**Consultation Response from KC,
Conservation & Design**

2026/91065 Queensgate Market, Princess Alexandra Walk, Huddersfield, HD1 2UJ

Discharge of details reserved by condition 5 (external door/windows) and 11 (external stairs/balustrade) on previous permission 2024/90270 for Listed Building Consent for demolition, alteration, refurbishment and extension to create library, food hall and public realm (part within a Conservation Area)

Date Responded: 10/6/26

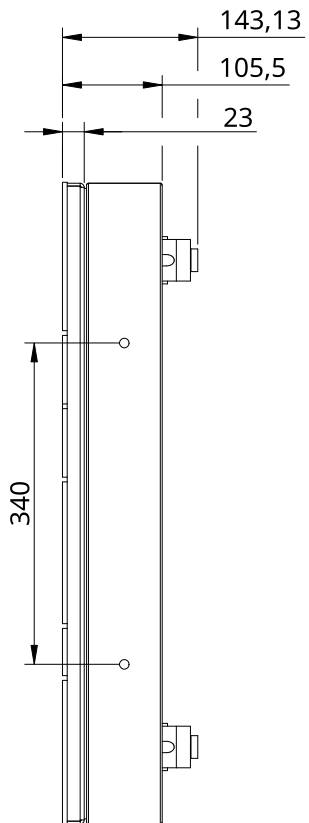
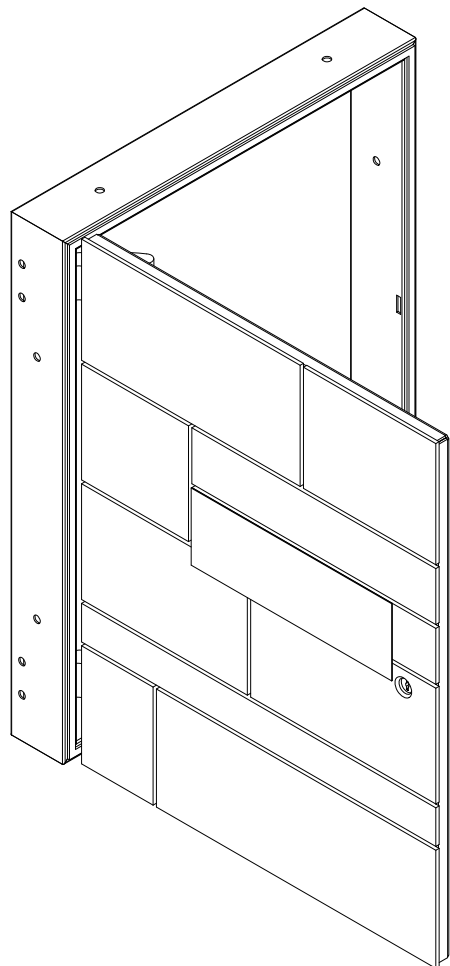
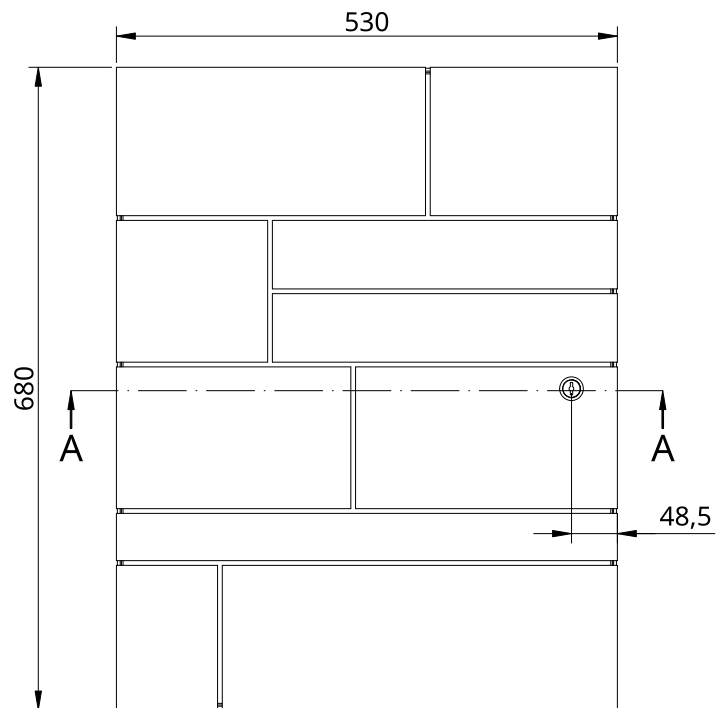
These 3 new openings are in the same elevation as the listed Stellar ceramic panels. The proposals would ensure that the new openings would be disguised by using stone cladding so they would not detract from the listed ceramic art panels. The proposed stone clad door document and plans show details of 1 door and 2 dry riser inlet boxes, these would all be clad in thin slips of natural stone to match the existing masonry wall.

The submitted details are adequate to discharge the condition.
